May 7, 2020

SUBJECT: SF-19-018 – Branding Iron at Sterling Ranch Filing No. 2 - Response Letter

### SAND CREEK BANK STABILIZATION PLAN

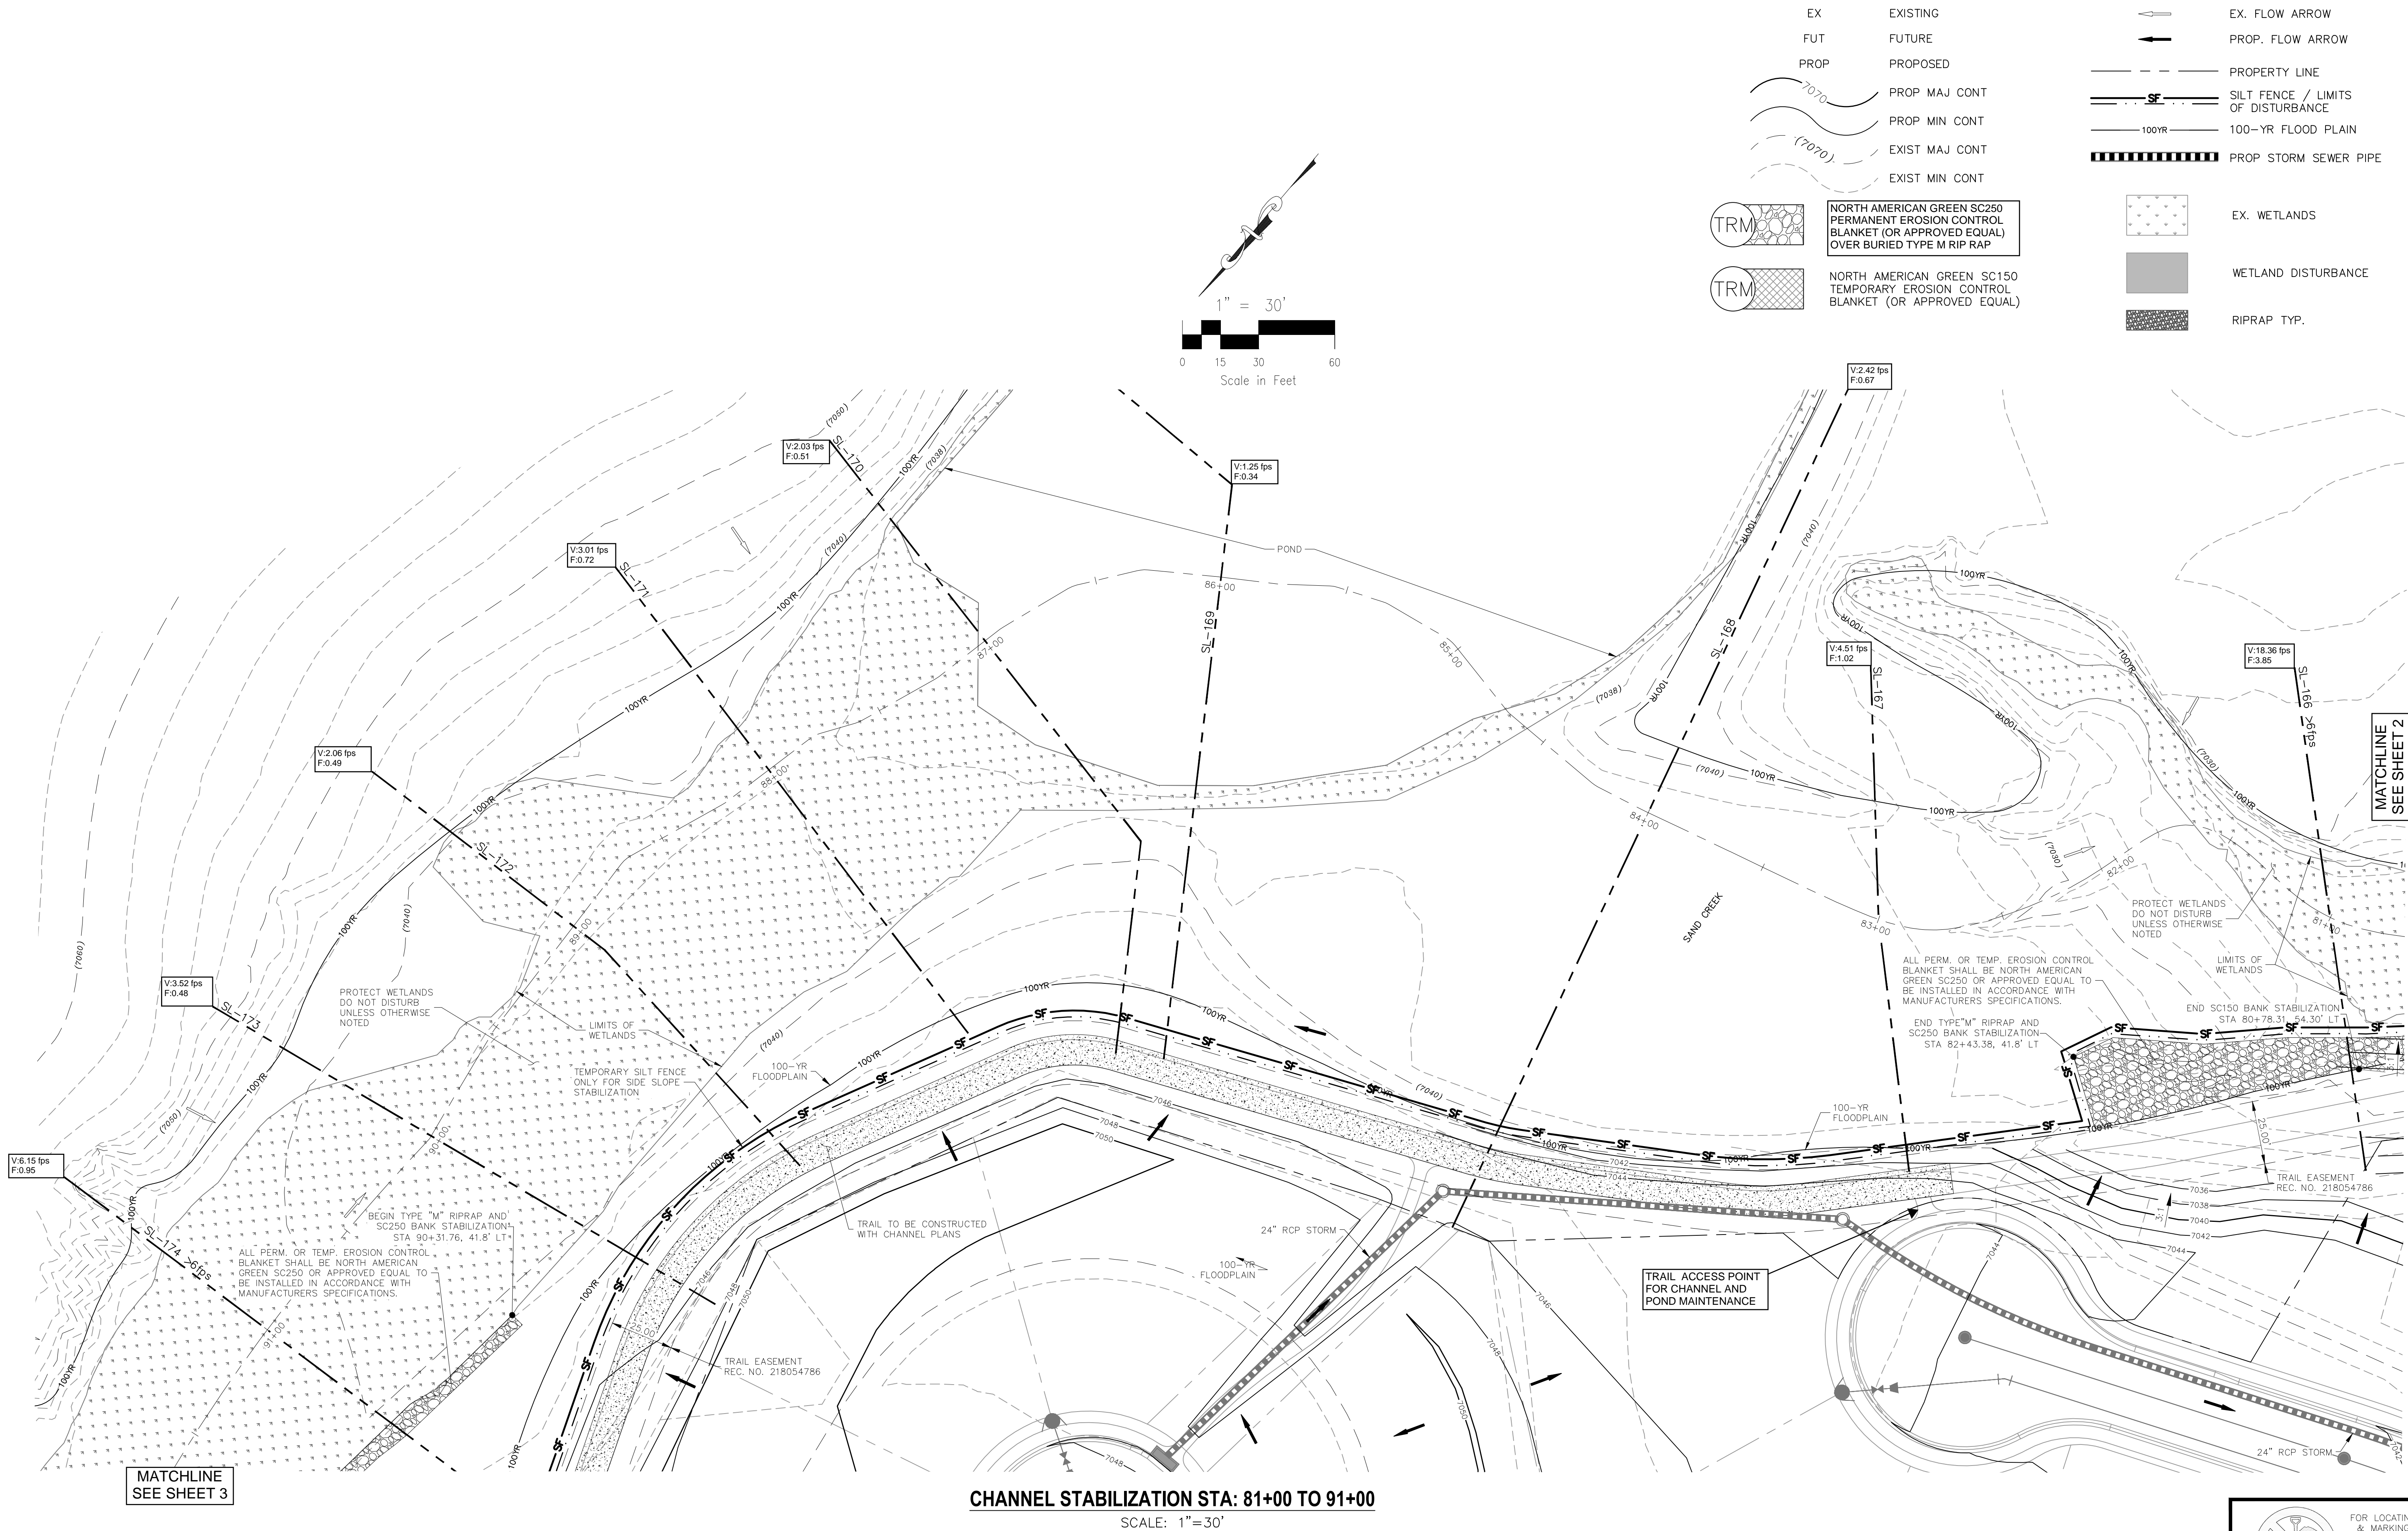
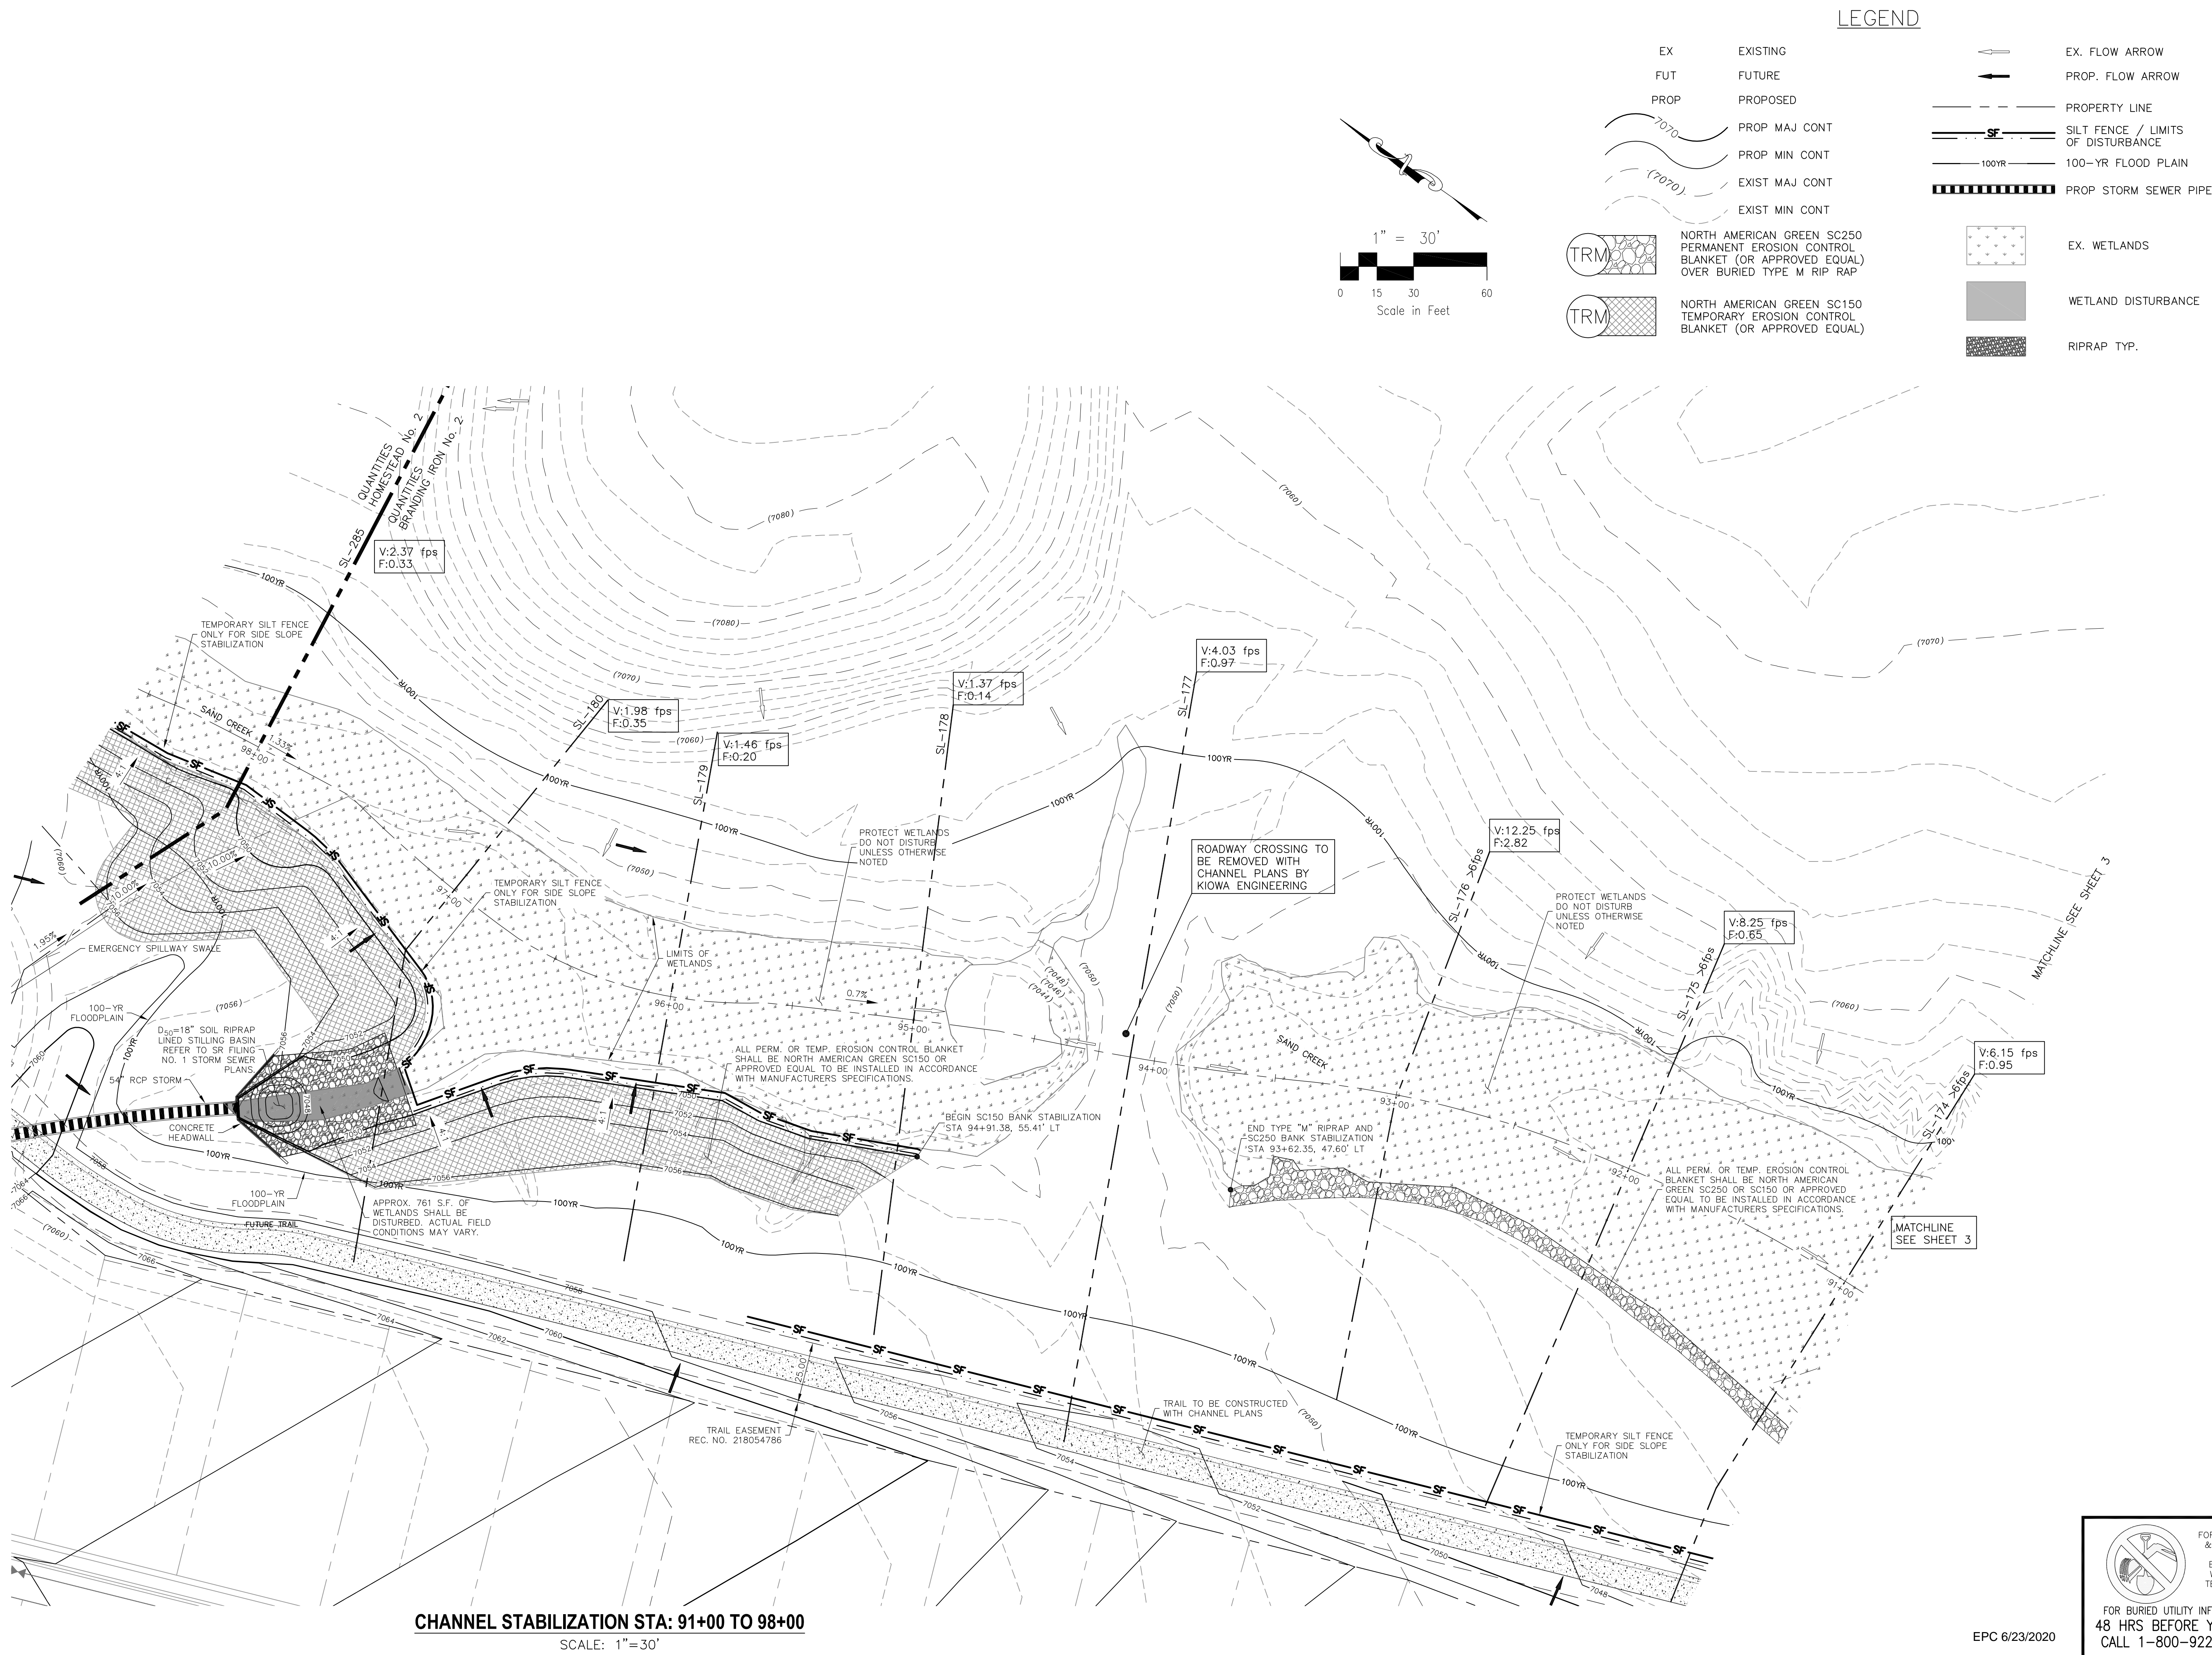
1. Sand Creek channel construction plans:
 - a. Provide a complete channel plan and profile for the applicable reaches.

- b. The channel design needs to be verified for overall stability including velocities and shear stresses with the proposed blanketing (ECB / TRM).
 - c. See redlines on bank stabilization plans. **Partially resolved; see updated/remaining redlines. Comments addressed on Bank Stabilization Plans. See below regarding trail access.**

PROPOSED DRAINAGE MAP

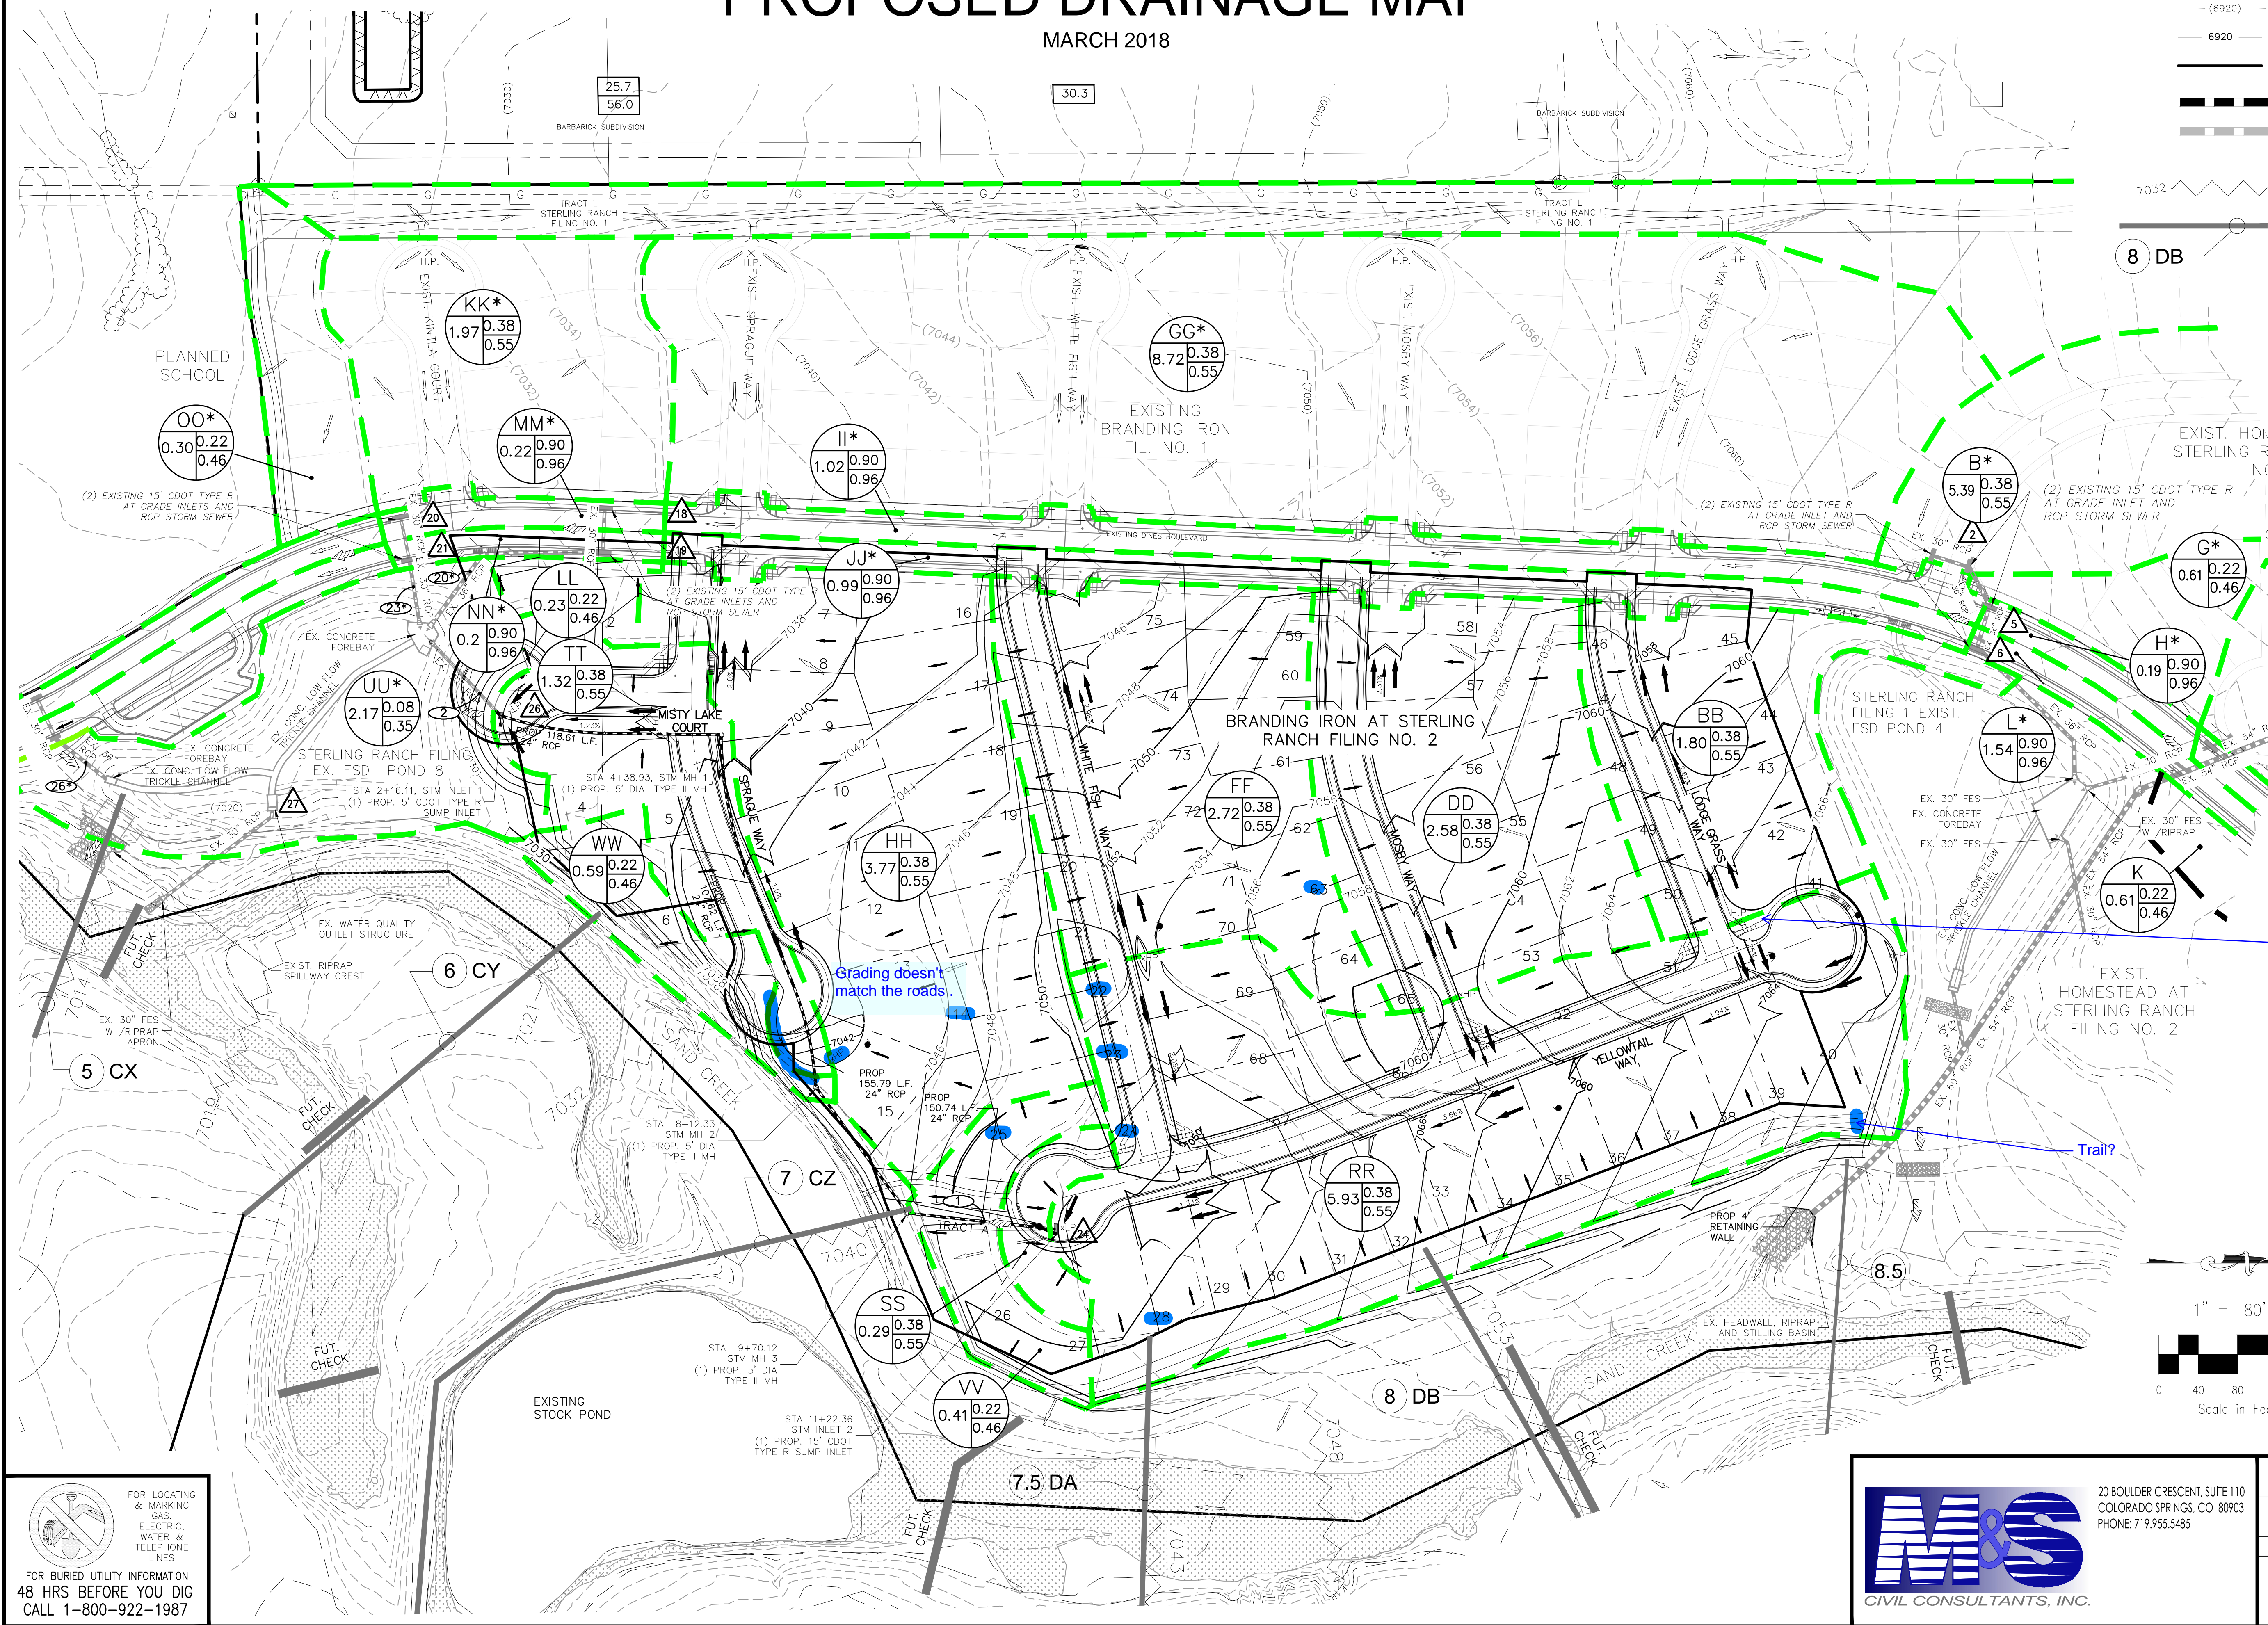
1. See FDR redlines. Partially resolved; see updated/remaining minor redlines. **Partially resolved; provide the correct proposed drainage plan in the report. Reference second review redlines on that sheet. Provide the signature date on engineer's stamp. The corrected Proposed Drainage plan has been included per the second review. The Date has been added to the stamp.**
2. Resolved.
3. Resolved.
